Response to Planning application from Hertfordshire County Council (T and CP GDP Order 2015)

District ref: 6/2023/2136/COND
HCC ref: WH/18732/2023
HCC received: 30 October 2023
Area manager: Manjinder Sehmi
Case officer: Chris Carr

Car Park Salisbury Square Hatfield AL9 5AD

Submission of details pursuant to condition 2 (construction management plan), 3 (archeological written scheme of investigation), 4 (Arboricultural method statement), 7 (petrol interceptors and treatment devices) and 9 (surface water drainage) on planning permission 6/2021/3422/MAJ

Routing plan

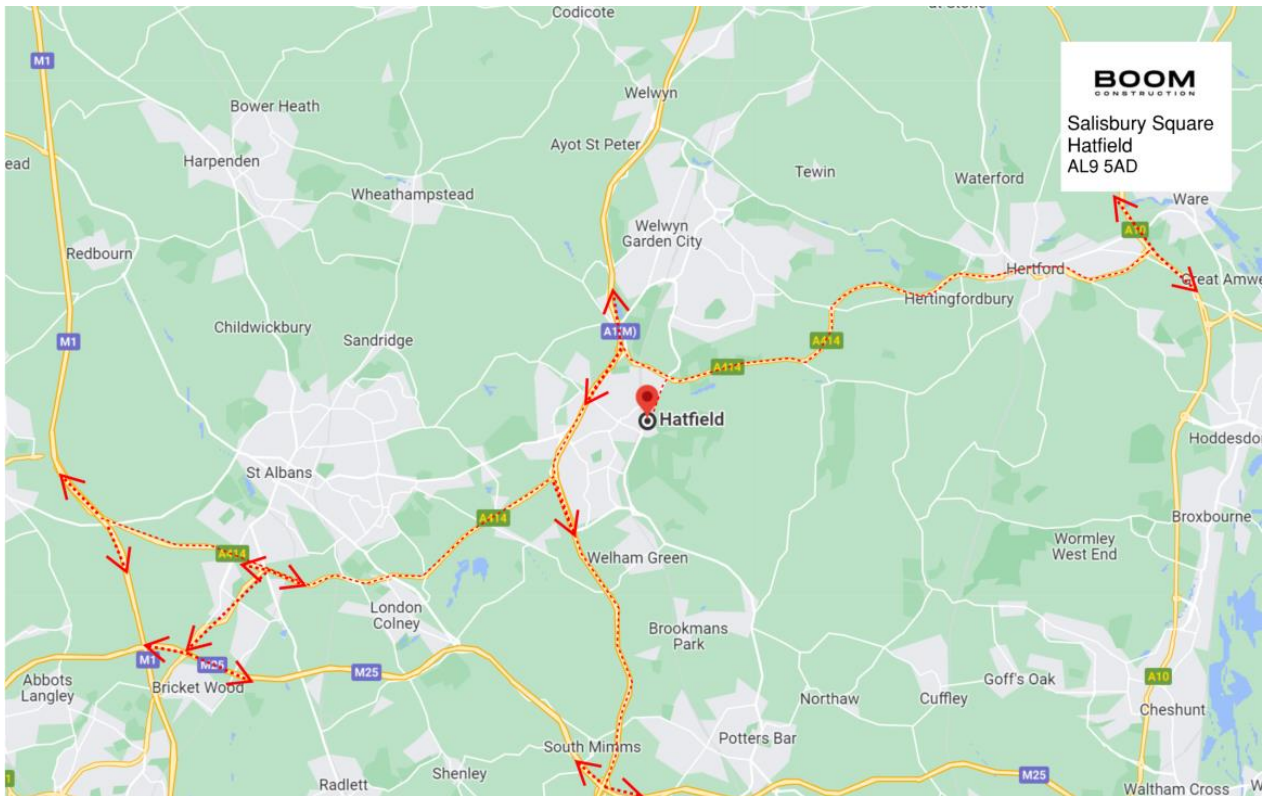
No routing plan has been provided, however the CMP states that no deviations or special controls are in place on any of the local roads. It is expected that deliveries would be from the site via the A1000 Great North Road and the A414, A1 & M1/M25. This is considered acceptable.

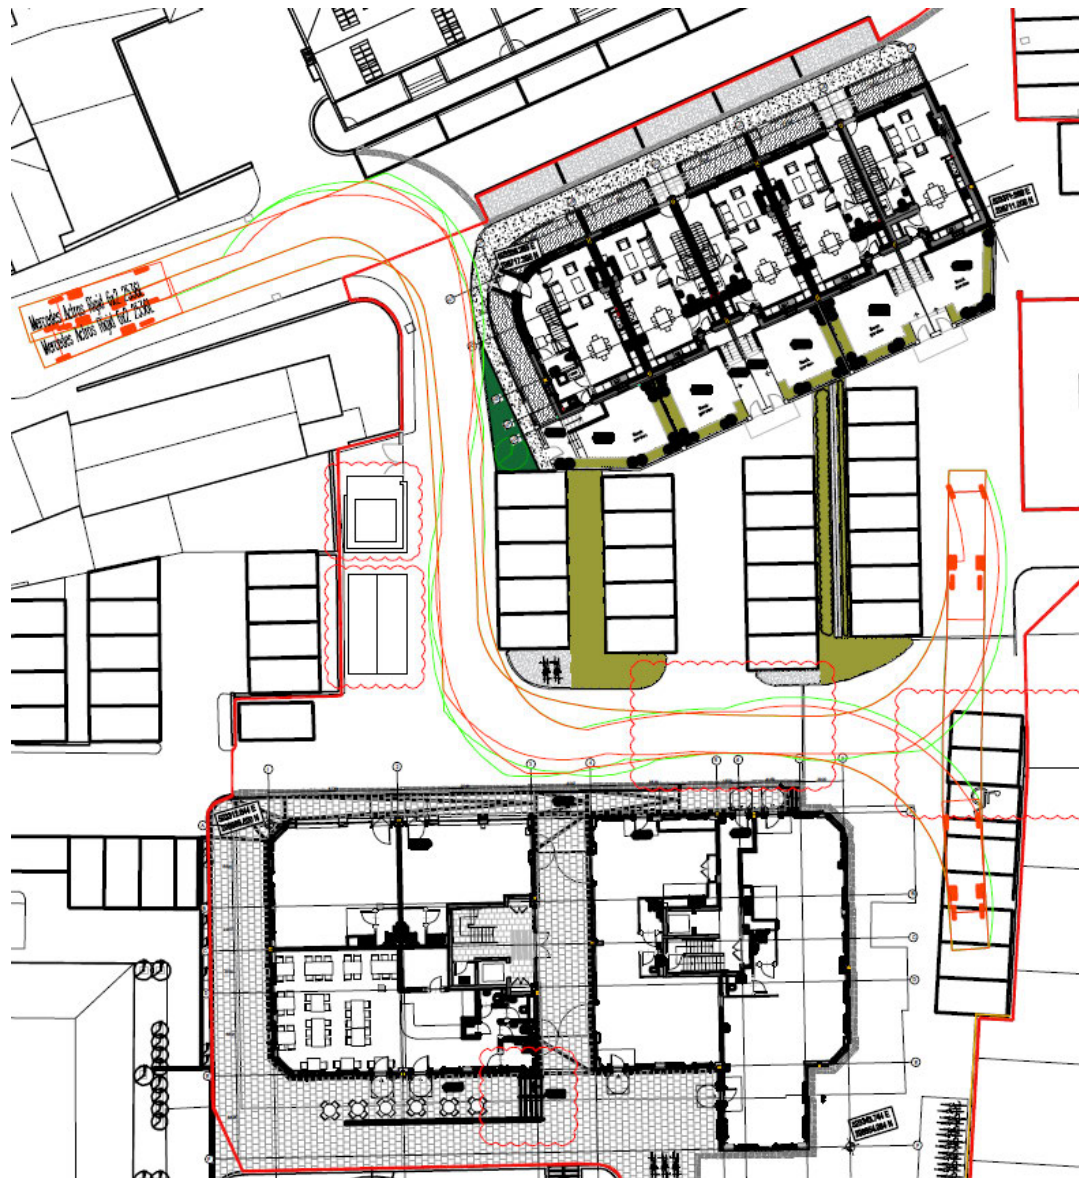
d. The CMP includes a drawing of the proposed site set up. This shows the location of parking spaces, site accommodation and storage area. This is considered acceptable.

e. The proposed site set up drawing shows the location of the proposed vehicle wash down area and this is acceptable.

j. The proposed site set up drawing shows the provision of storage / access arrangements for pedestrians & vehicles / temporary accommodation units / wheel washing facilities and parking area. This is acceptable.
